About the application

Application number: 2026/91063	
What is the application for?:	Re-instatement and repair of existing building including alterations to roof and
Address of the site or building:	382, Huddersfield Road, Mirfield, WF14 9DL
Postcode:

User comments

Drawing Number: TR-A25-0705-A7
Scale: 1 : 50@A1

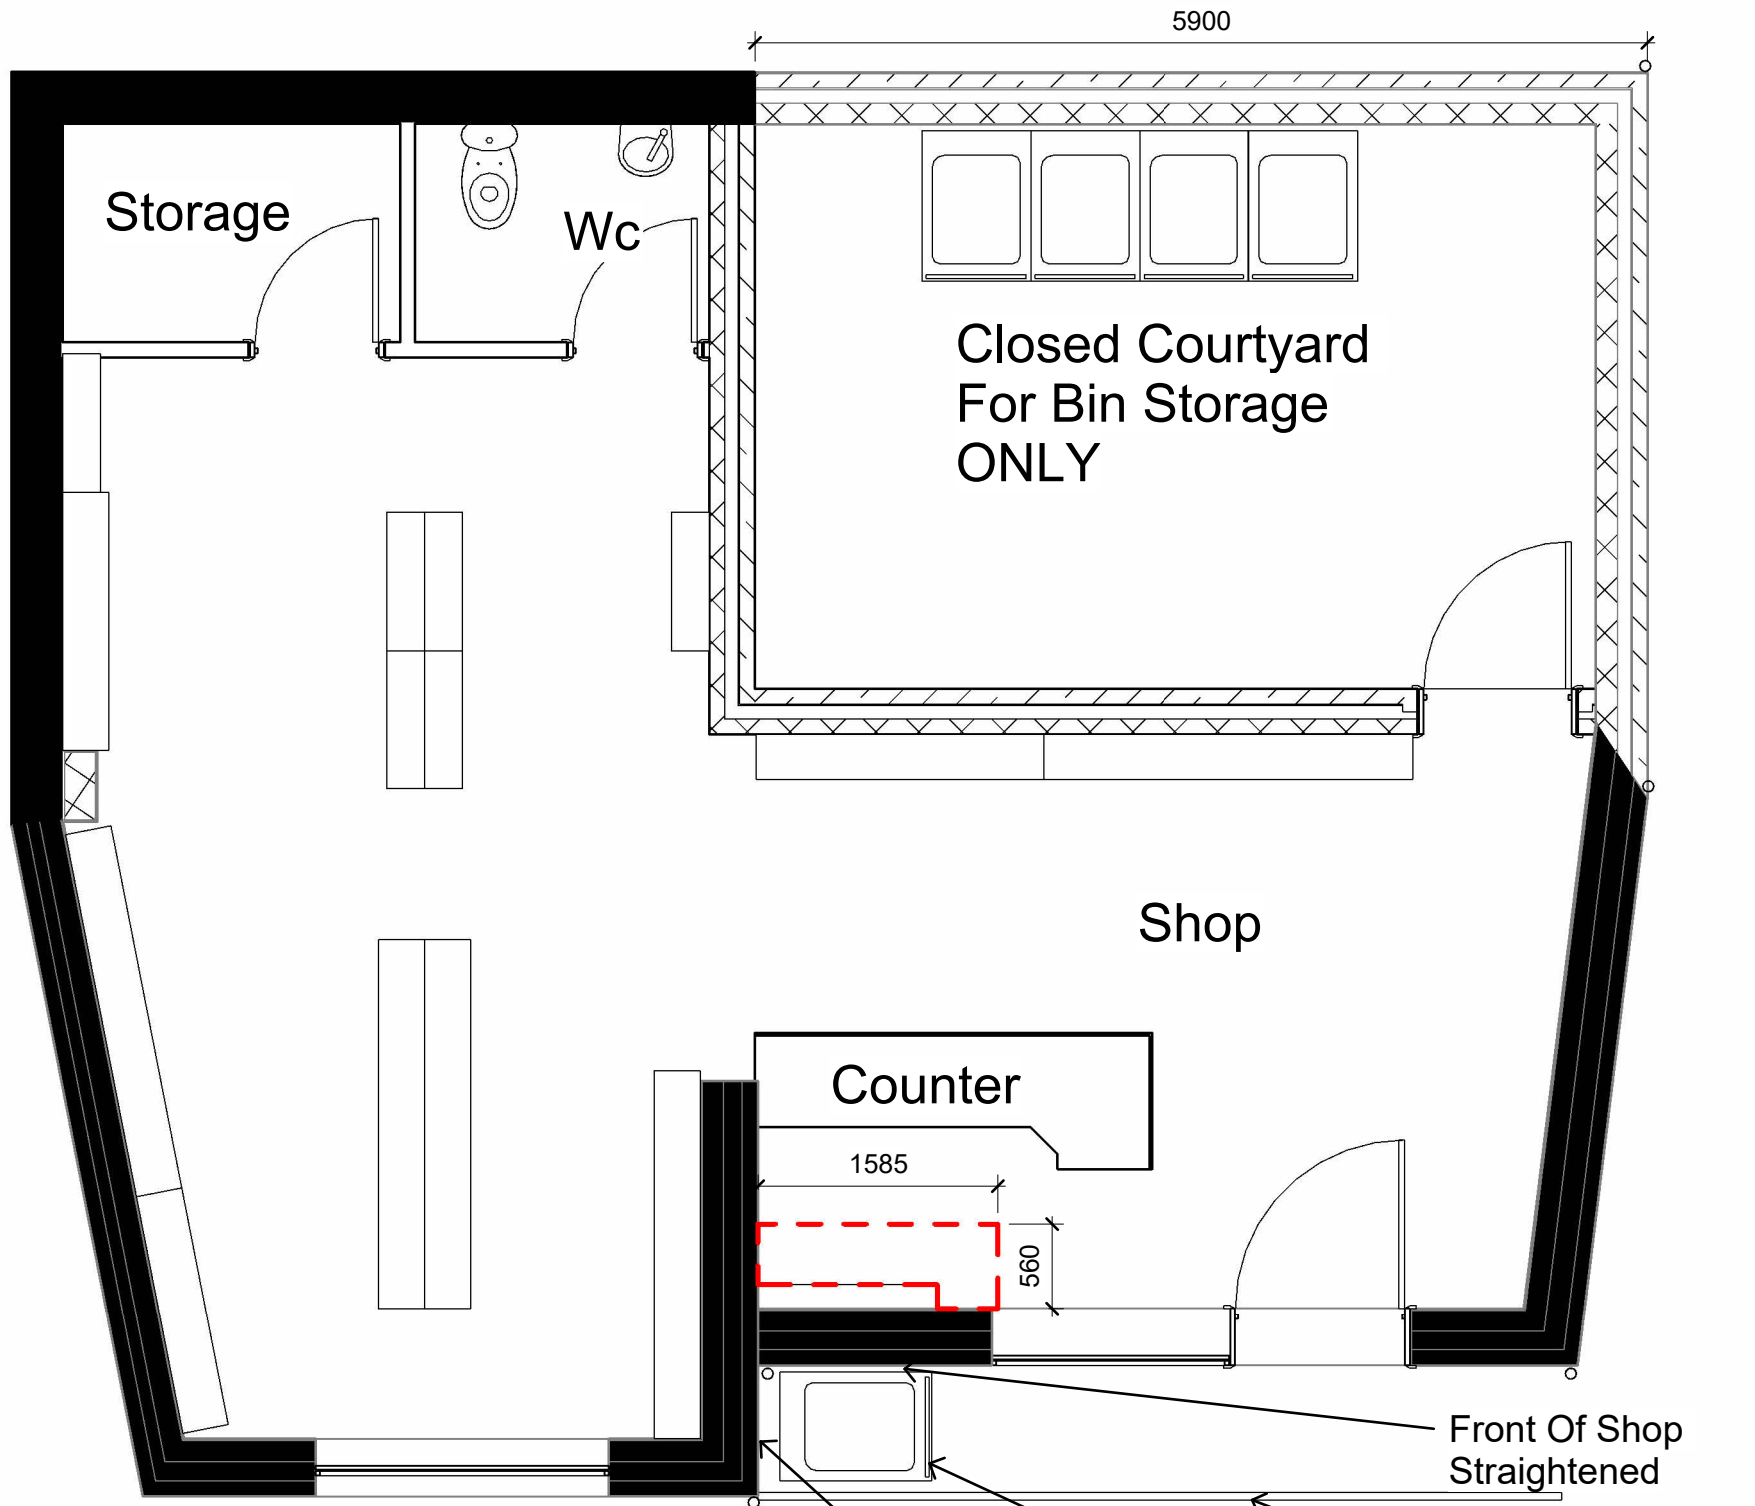
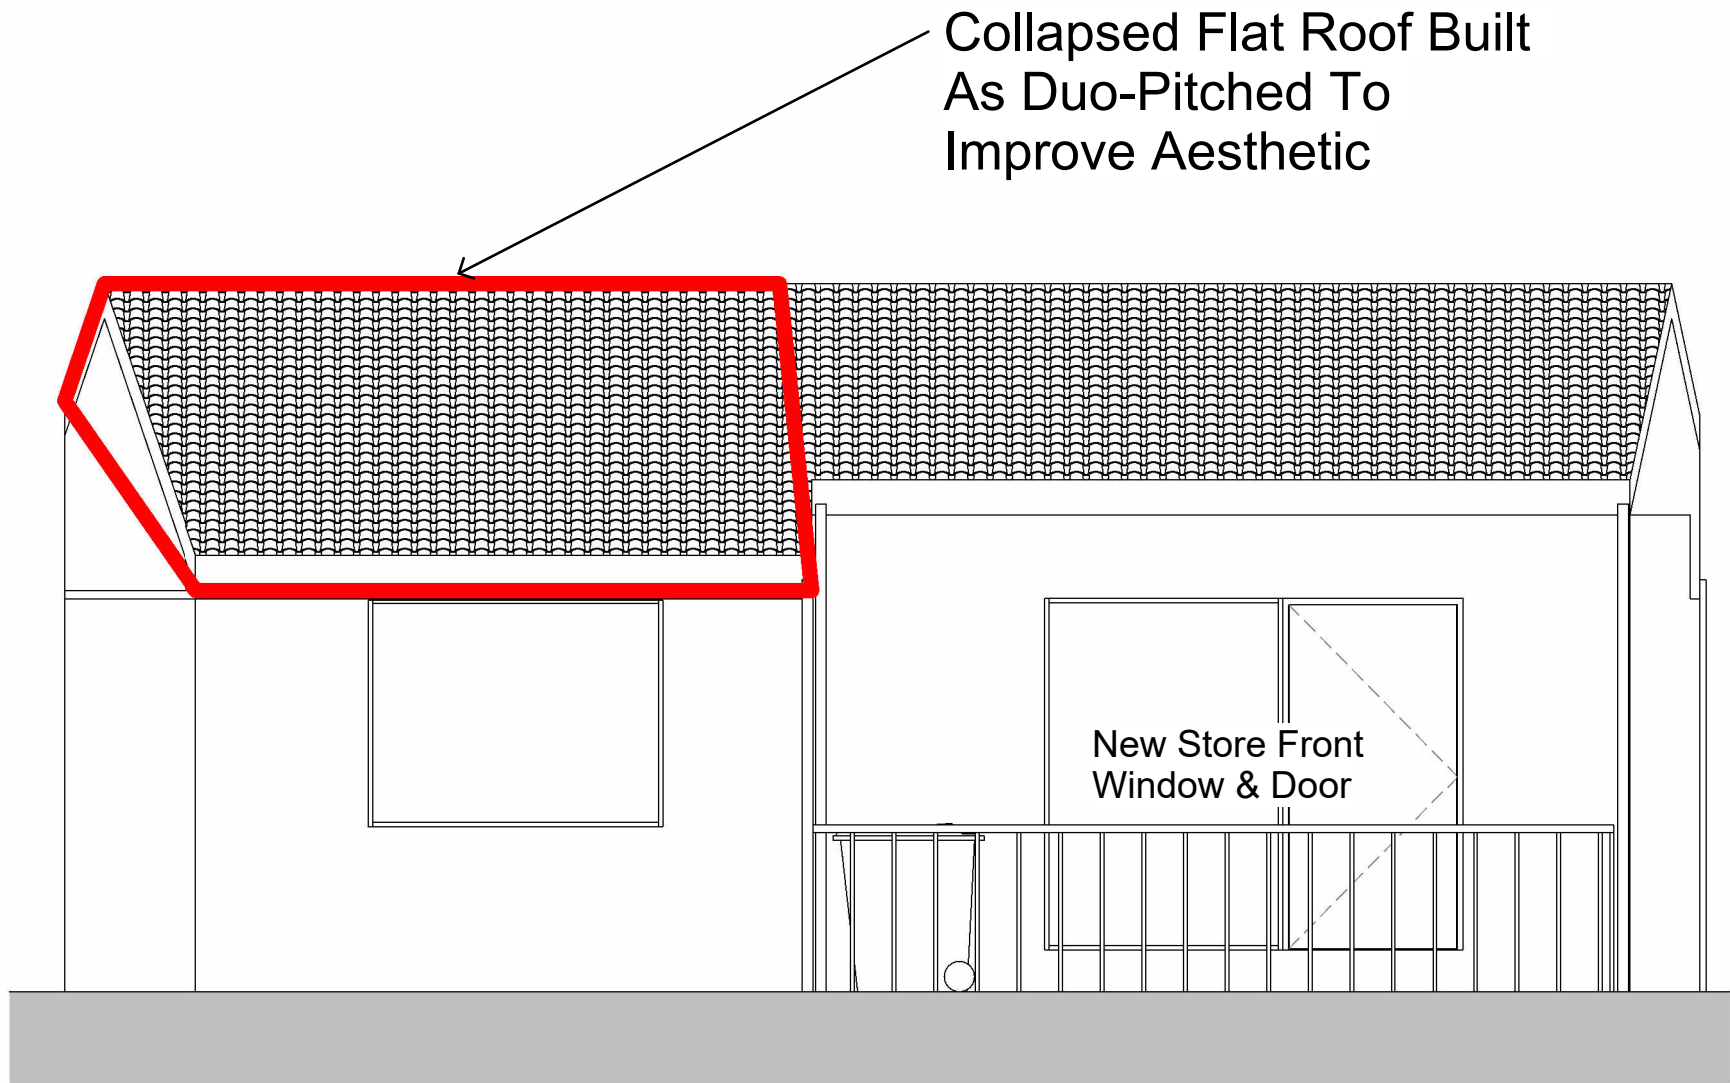
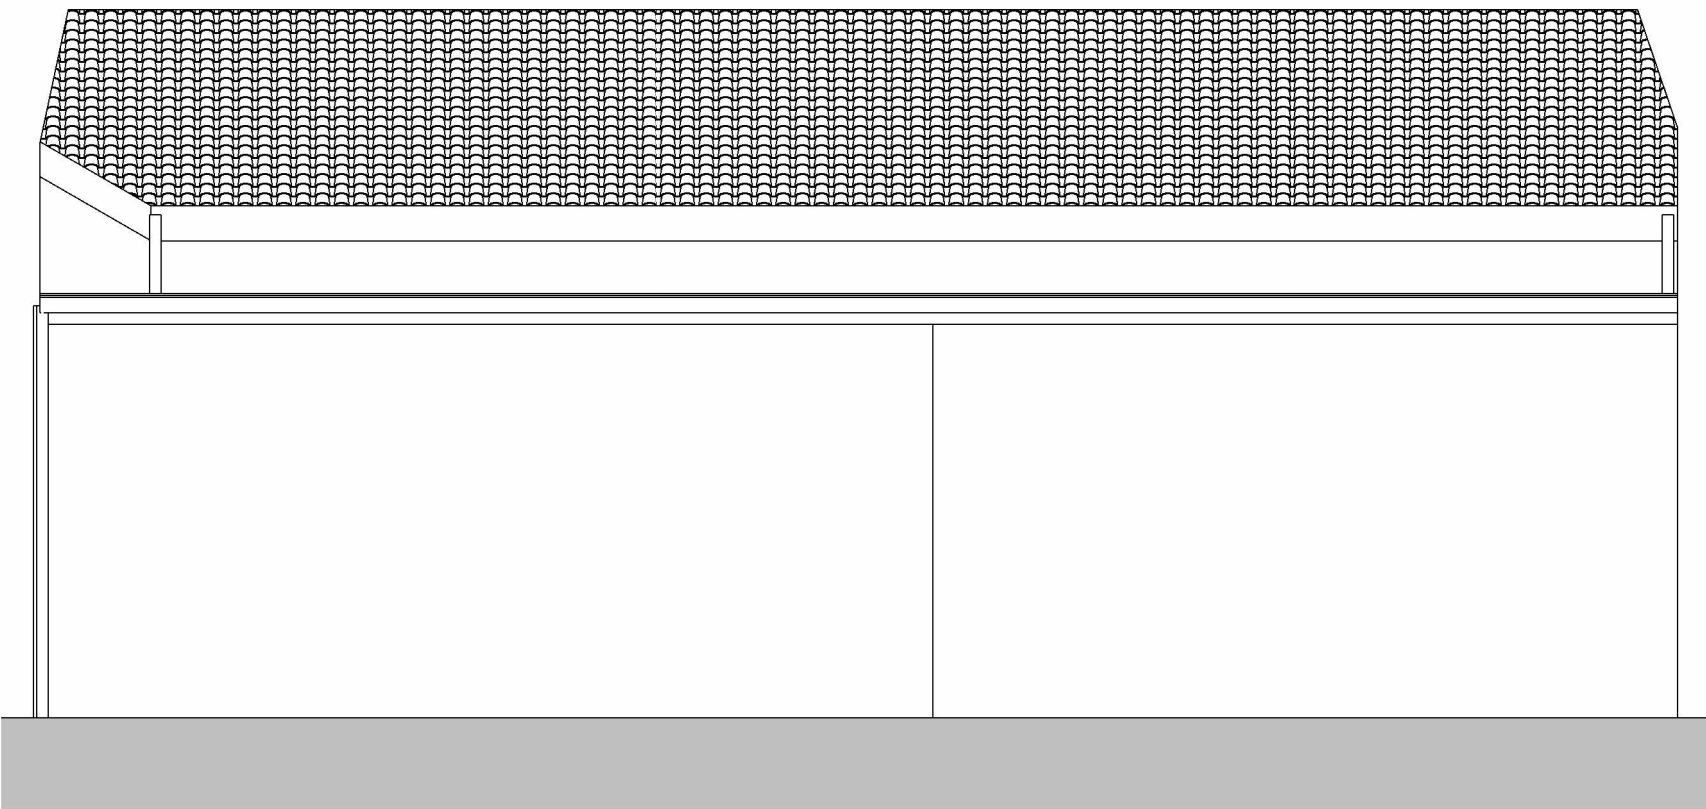
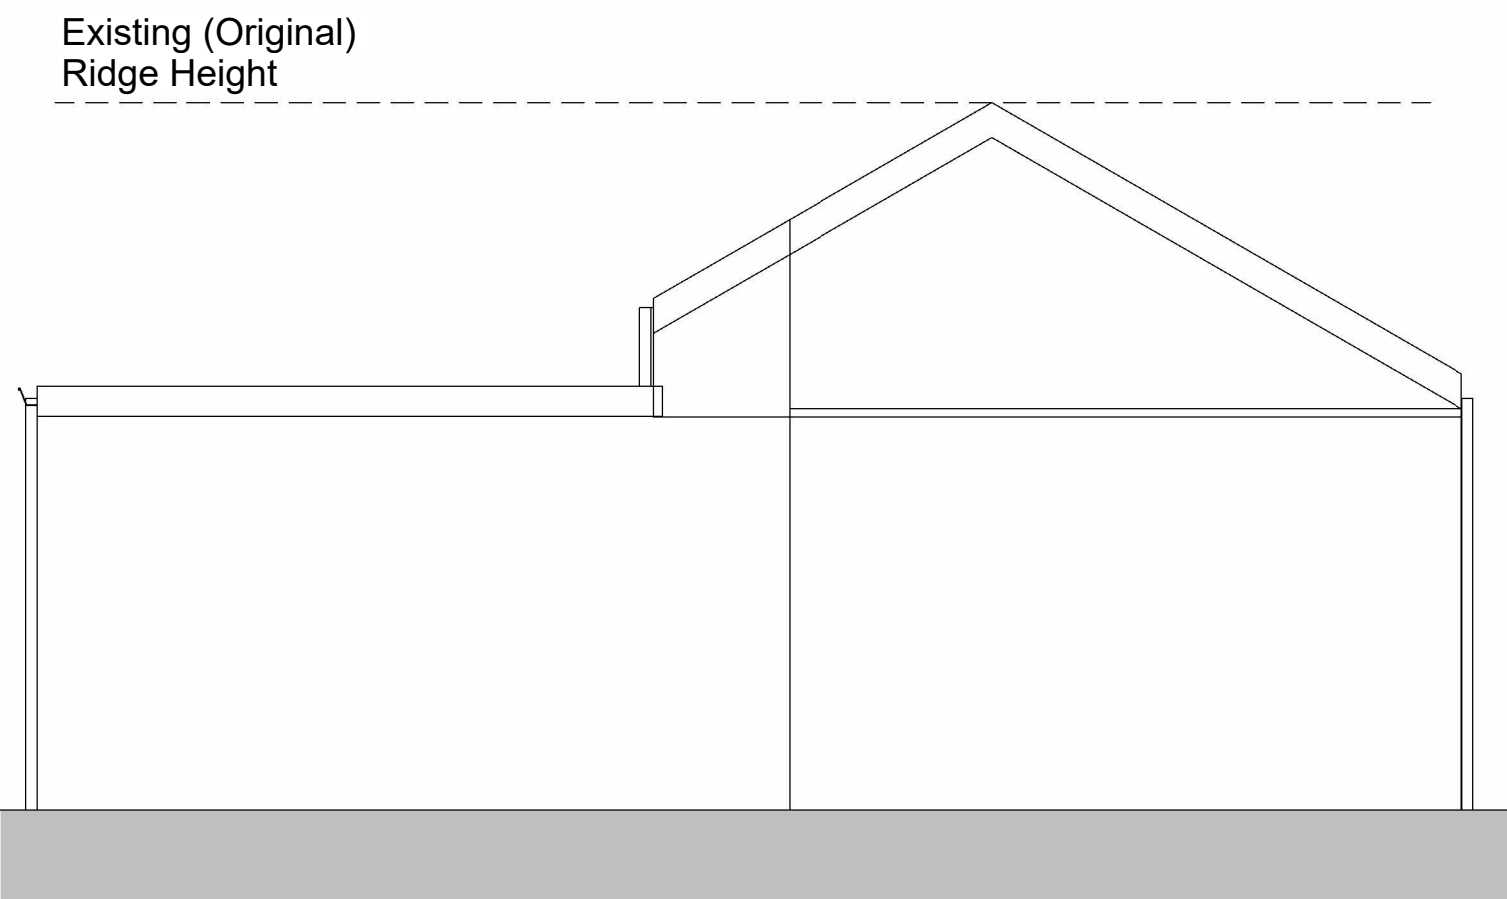
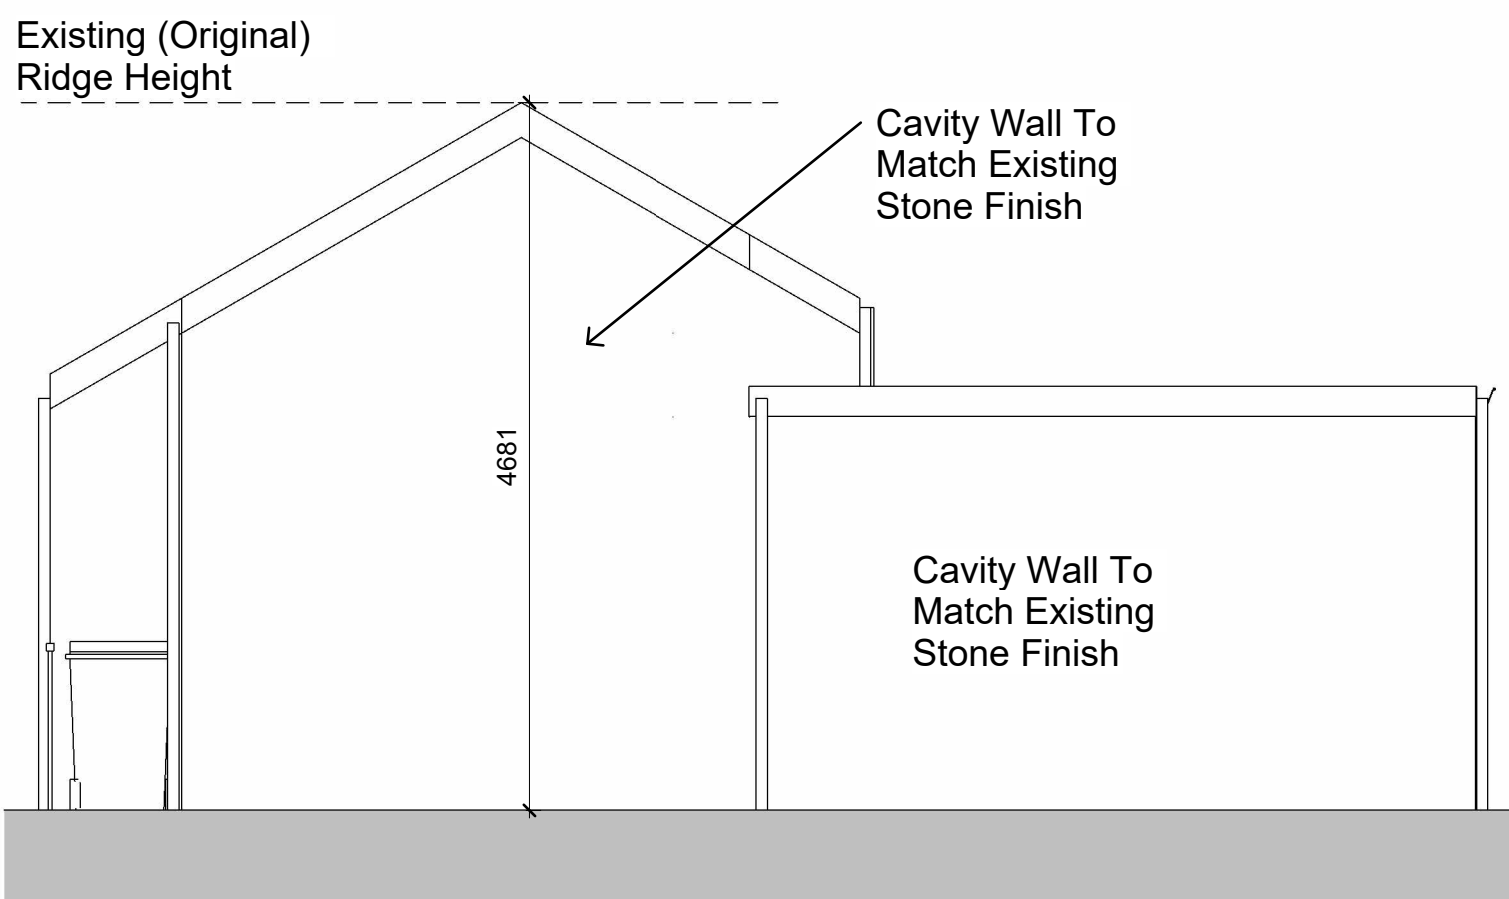
Drawing id 1135704 show the height as 4681mm

Proposed height is 4681mm

There is a public right way steps upwards next to this building ,this not shown on any drawings.

The measurements shown do not include this public right of way or the height of the steps.

There is no datum line from which the measurements are taken.

The 1 to 50 scale used only works on a specific size of drawing being A1 .Further dimensions need to be added to the plans.

This wording is a licence to build whatever size building you so wish.
